A303 Sparkford to Ilchester Dualling Scheme TR010036

9.25 Responses to the Examining Authority's Second Round of Written Questions

**Responses to the Examining Authority's Second Round
of Written Questions**

Regulation Number:	
Planning Inspectorate Scheme Reference	TR010036
Application Document Reference	9.25
Author:	A303 Sparkford to Ilchester Dualling Scheme: Highways England Project Team

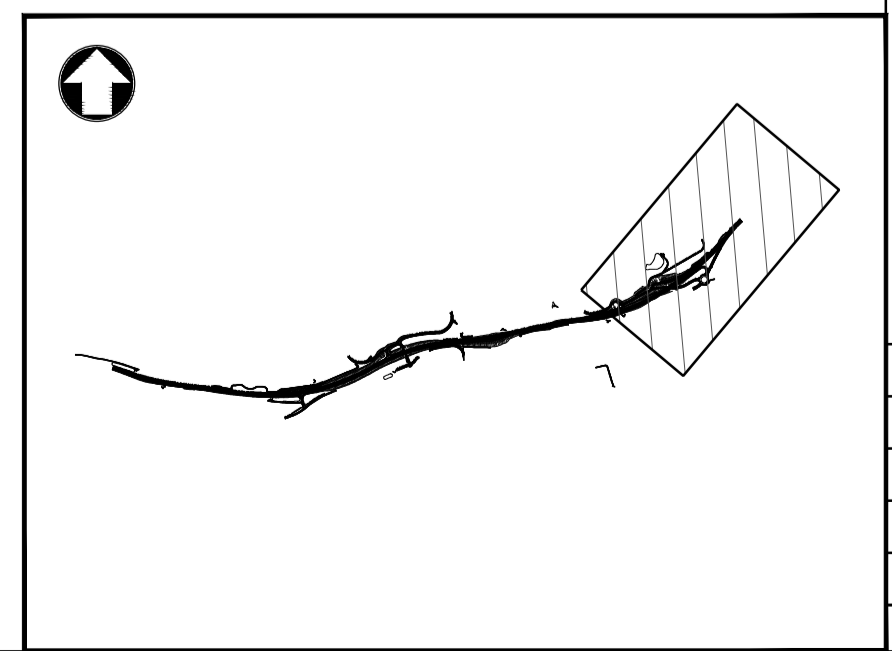
2.6.7	The Applicant	<p>Hazlegrove Underbridge</p> <p>The Applicant's Written Submissions of Oral Case [REP4-020] states that there are a number of technical and environmental considerations and assessments in relation to lighting the underpass at night, including the effect on ecology, the landscape impact given the sensitive location in relation to Hazlegrove RPG and the absence of an assessment of the on the safety and of motorised users.</p> <p>Please can the Applicant submit an assessment of the effect of providing lighting for NMU within the underbridge at night in relation to these matters, having regard to the use of best practice to minimise light spill from the underbridge.</p>	<p>The applicant would firstly like to clarify that illumination of the underbridge during the daytime has not been provided for security reasons. It is proposed to illuminate the underbridge during the day in order to minimise the contrast between daylight along each approach and relative darkness under the structure that drivers along the local road (Camel Hill Link) might experience.</p> <p>Illumination of an underbridge or underpass during darkness would normally be provided as part of the wider illumination of the NMU or vehicular highway network that leads to it. An underbridge or underpass would not normally be illuminated at night where this is located on an otherwise unlit part of the network. Such a relatively localised section of illumination may introduce an un-necessary change in lighting levels for drivers and may actually attract antisocial behaviour.</p>

ExQ2	Question to	Question	Response
			<p>Hazlegrove House Registered Park and Garden, and from Hazlegrove House as a visual receptor (view point 35). Due to the rural locality, it is considered unlikely that the PROW passing through the park (view point 38) would be used during hours of darkness, and so it is considered no additional adverse effects would be associated with this receptor.</p> <p>From a cultural heritage perspective, the additional lighting would also result in adverse effects to the setting of Hazlegrove House Registered Park and Garden. During daylight lighting columns are likely to be visible in views across the RPG specifically those looking south west from within the park, and from Hazlegrove House. This would have an additional adverse impact on the setting of the RPG. During hours of darkness the light will be extremely visible and will end views across the RPG, again, specifically those looking south west from within the park, and from Hazlegrove House. This would introduce an uncharacteristic modern element into these views resulting in an adverse effect to the setting of the RPG. Although as planting becomes established the columns would become obscured by trees, the lighting itself is likely to be visible above the tree line, resulting in further permanent adverse effects.</p> <p>The introduction of additional lighting along the Hazlegrove Underpass and approaches would have additional adverse effects to protected species. Artificial light can cause a range of problems for nocturnal species; for bats the main concerns are the attraction that light from certain types has on a range of insects; and the presence of lit conditions posing a barrier to movement. Studies have shown that lighting along roads creates barriers which many bat species cannot cross, even at very low light levels, and species may alter flight paths which link roosts and foraging grounds to avoid artificial light. Many night-flying insects are attracted to light, especially those light sources that emit an ultraviolet component or have a high blue spectral content. This is particularly a problem in an otherwise dark area, and it is thought that insects are attracted to lit areas from beyond the immediately illuminated habitat. This could lead to habitats adjacent to the Hazlegrove Underpass supporting reduced numbers of insects, reducing the foraging resources available to bat populations here. Artificial lighting could also increase the chances of predation, particularly by owls for example, and therefore bats may further modify their behaviour in response. Other nocturnal species within the area surrounding the Hazlegrove Underpass are badgers, barn owls and great crested newts, all of which could be similarly disturbed or inhibited by artificial lighting in this area.</p>
